**WEST SUSSEX COUNTY COUNCIL
STRATEGIC PLANNING CONSULTATION**

SUBJECT: FP/159/13

**Change of use from production of timber for bio mass use (Sui Generis) to land for private outdoor fitness training (D2 Assembly and Leisure) vehicular access from the A259 with 8 bay parking area within site (resubmission of FP/102/13/). This application is a Departure from the Development Plan.
AMENDED DESCRIPTION & SUBSTITUTE BLOCK PLAN.**

Land at Rookery Farm, Worms Lane, Flansham, West Sussex

Site Plan

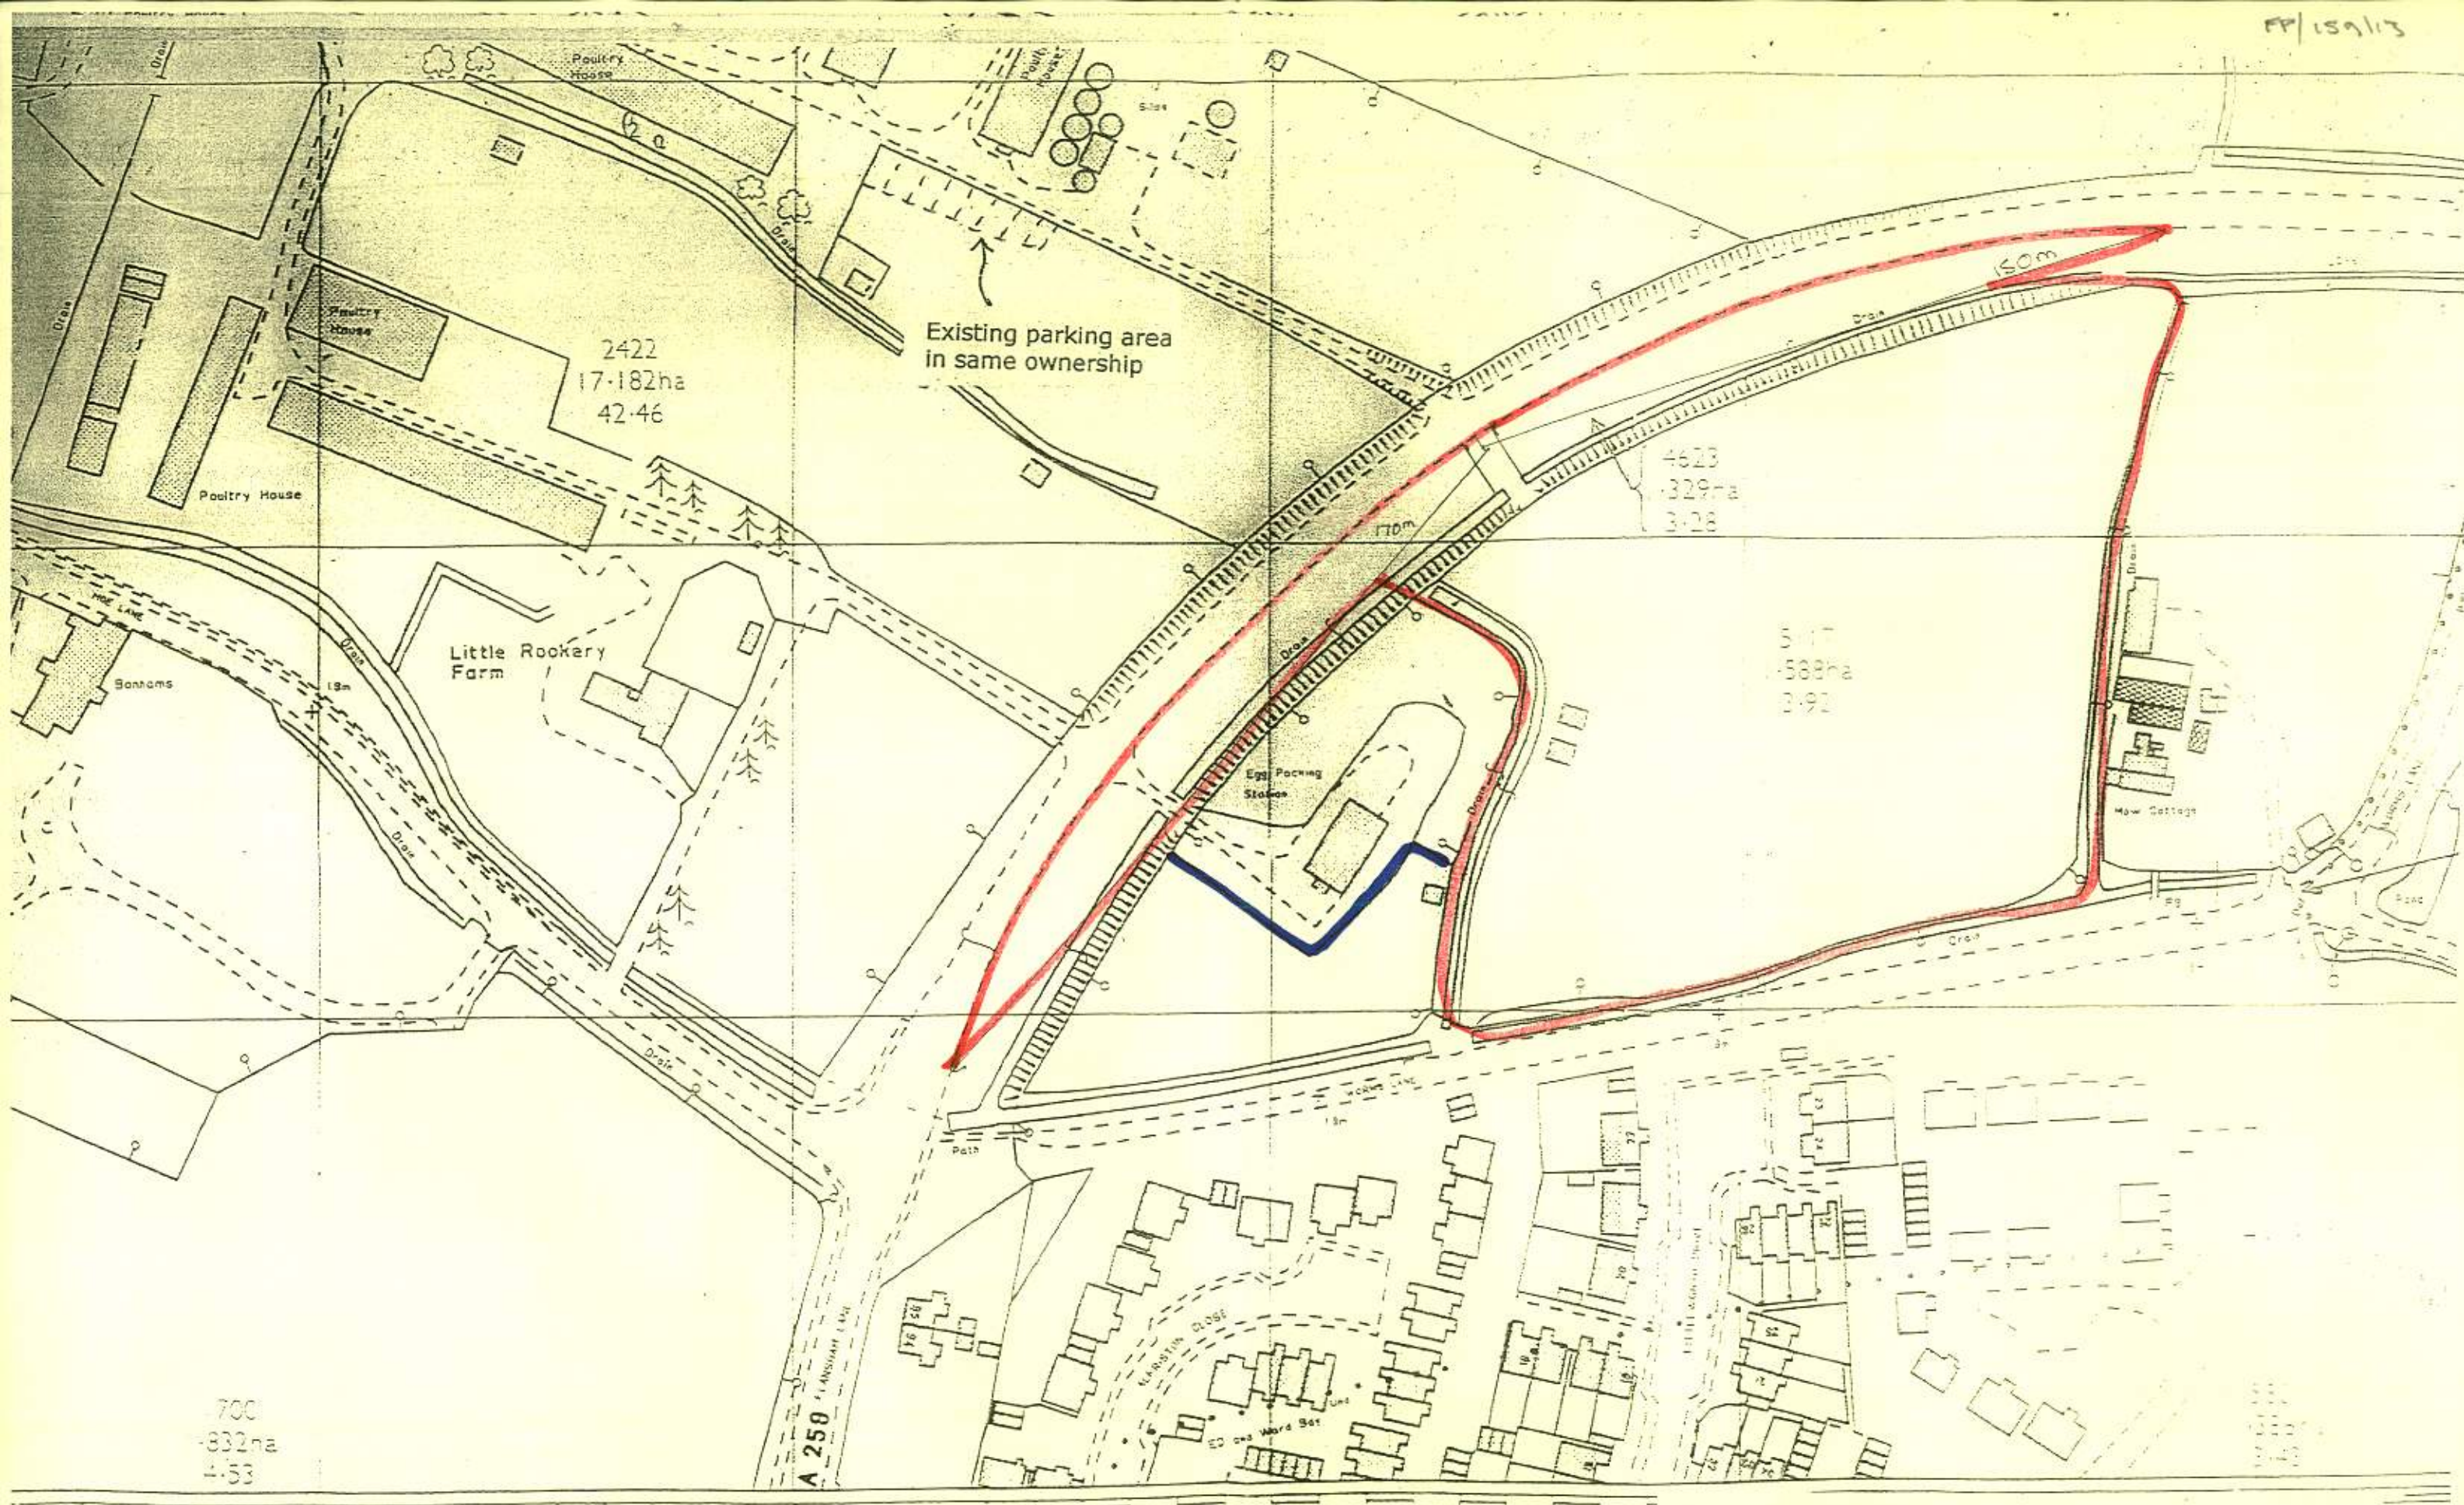
The plan indicates that an existing crossover will be used to provide access. However, from observation of the site it does not appear that the current arrangement is a formal vehicular crossover, but that access to the land has been gained by overrunning the verge and eroding vehicular tracks. Vehicles gaining access in this manner are likely to be originating from the Rookery Farm access directly opposite as opposed to approaching from either east or west along Worms Lane.

the appropriate design guidance. For a 60mph design speed visibility splays of 2.4m x 215m would be required; the applicant has provided 2.4 x 125/150m. These are considered to be substandard and no evidence has been submitted to demonstrate that sufficient visibility for the recorded road speed.

Little information is provided on the geometry of the access and whether two-way working would be possible; vehicles stopping or standing on the A259 carriageway waiting to gain access would pose a hazard to through traffic and could result in shunt type collisions. The kerb radii shown on the plan requires a very sharp turning manoeuvre which could only be undertaken at very low speeds. The sudden slowing on a derestricted 'A' road could again lead to shunt type collisions. No vehicle tracking has been provided to demonstrate that vehicles with larger turning circles, such as a mini-bus, would be able to access the site without impacting the opposing lane of traffic.
